7 August 2017

Carolyn McNally  
Secretary  
Department of Planning & Environment  
GPO Box 39, SYDNEY NSW 2001

Further to the meeting with yourself, representatives of the City of Sydney Council (Council) and Mirvac on 30 June 2017, we write to respond to the issues raised at the meeting.

Lower Ground GA Plan

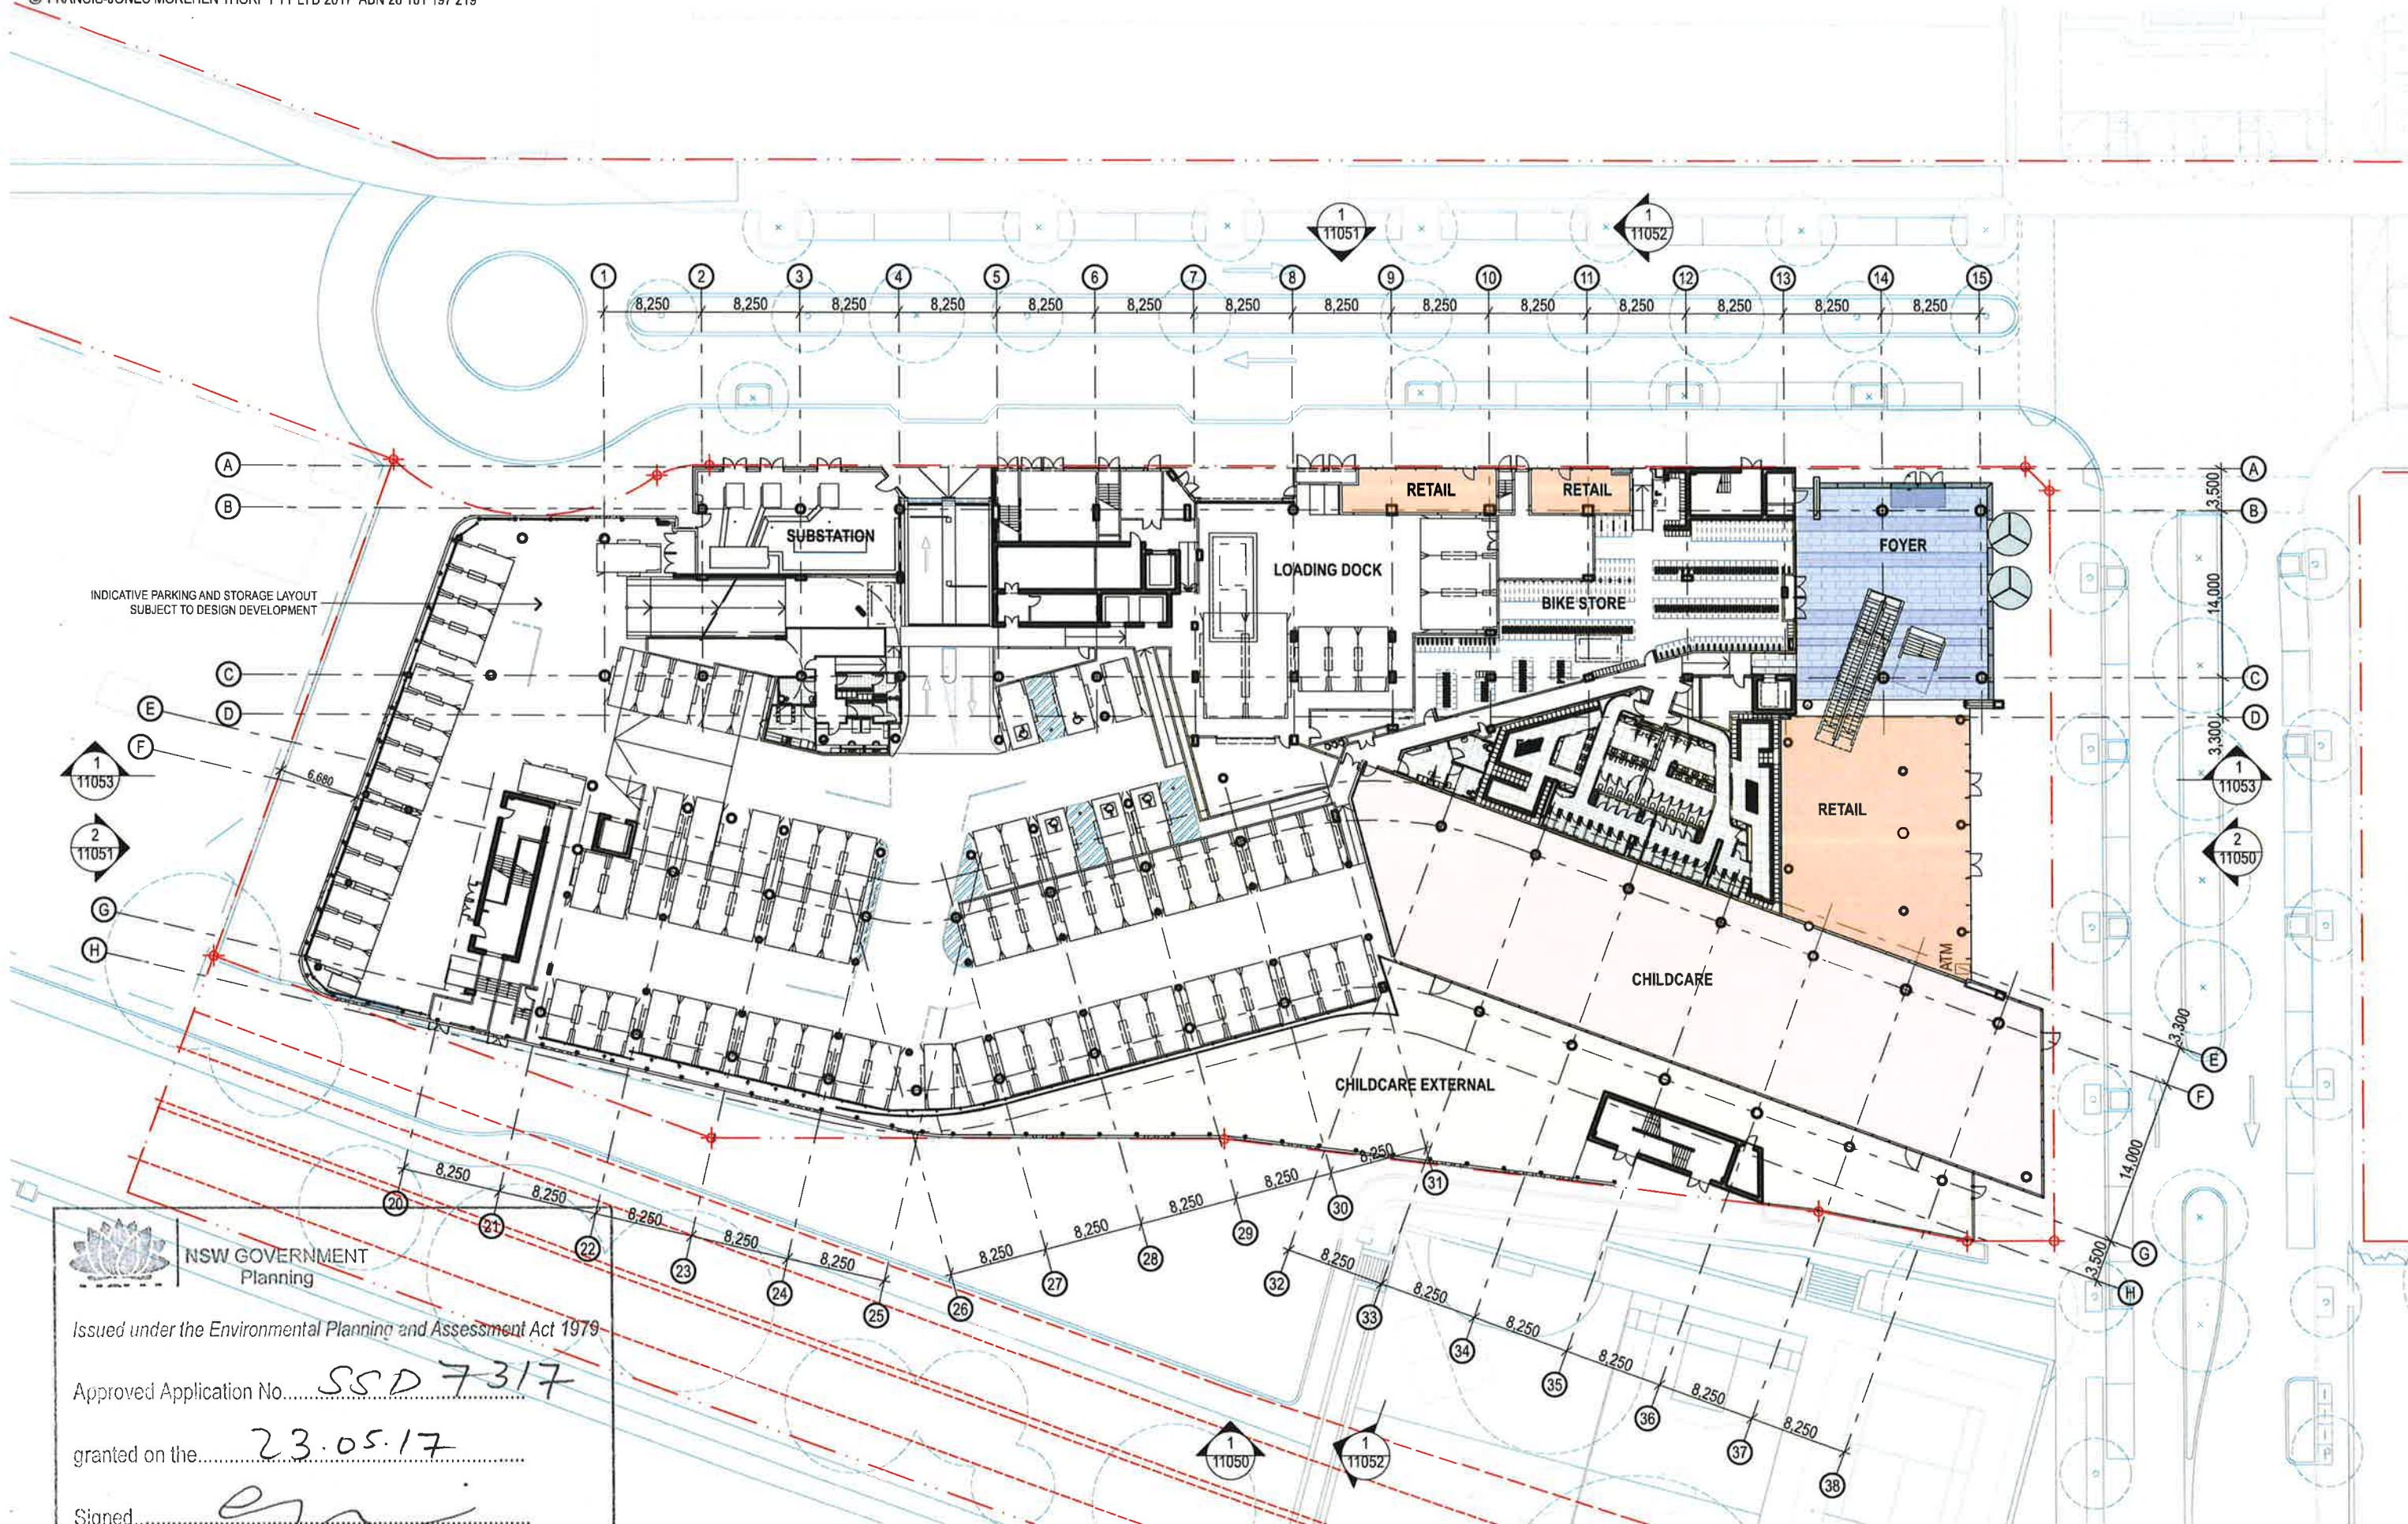
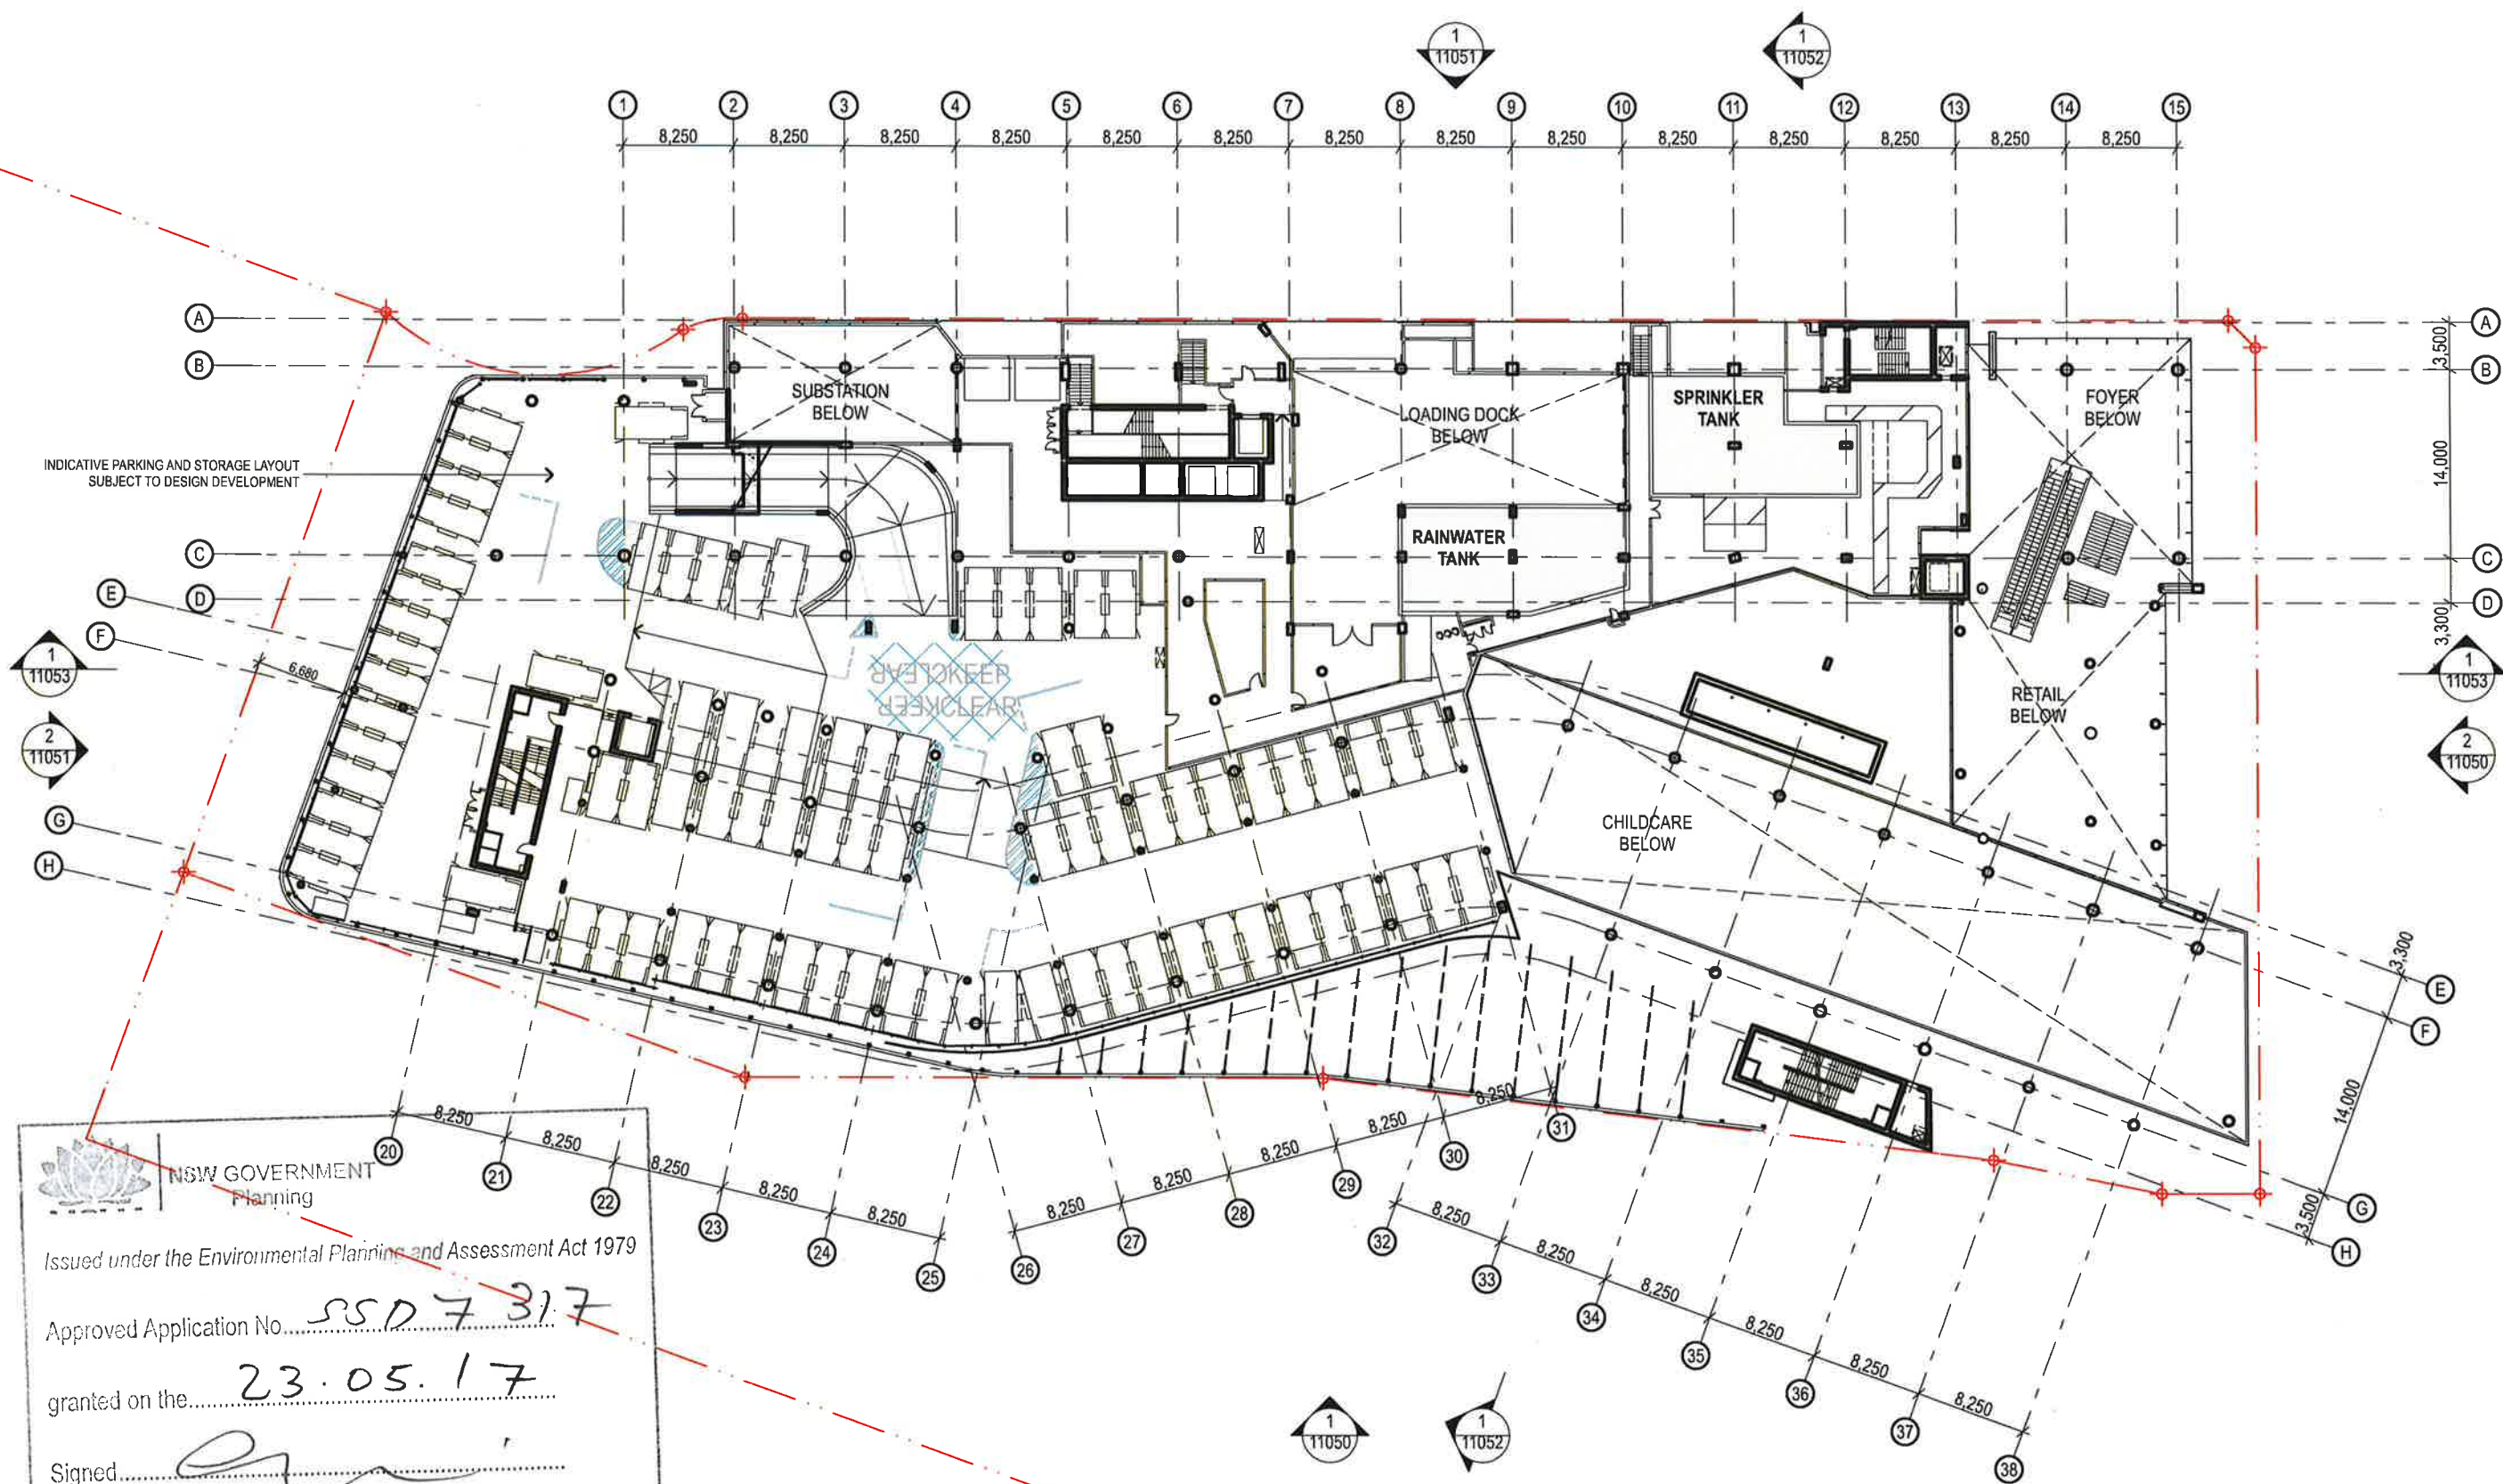
On 23 May 2017, the Department of Planning & Environment (the Department) issued approval of the amended plans for Building 1. The plans for Building 1 (stamped 23 May 2017) illustrate a total of 205 car parking spaces across the Lower Ground, Mezzanine and Upper Ground levels (refer to **Attachment A**).
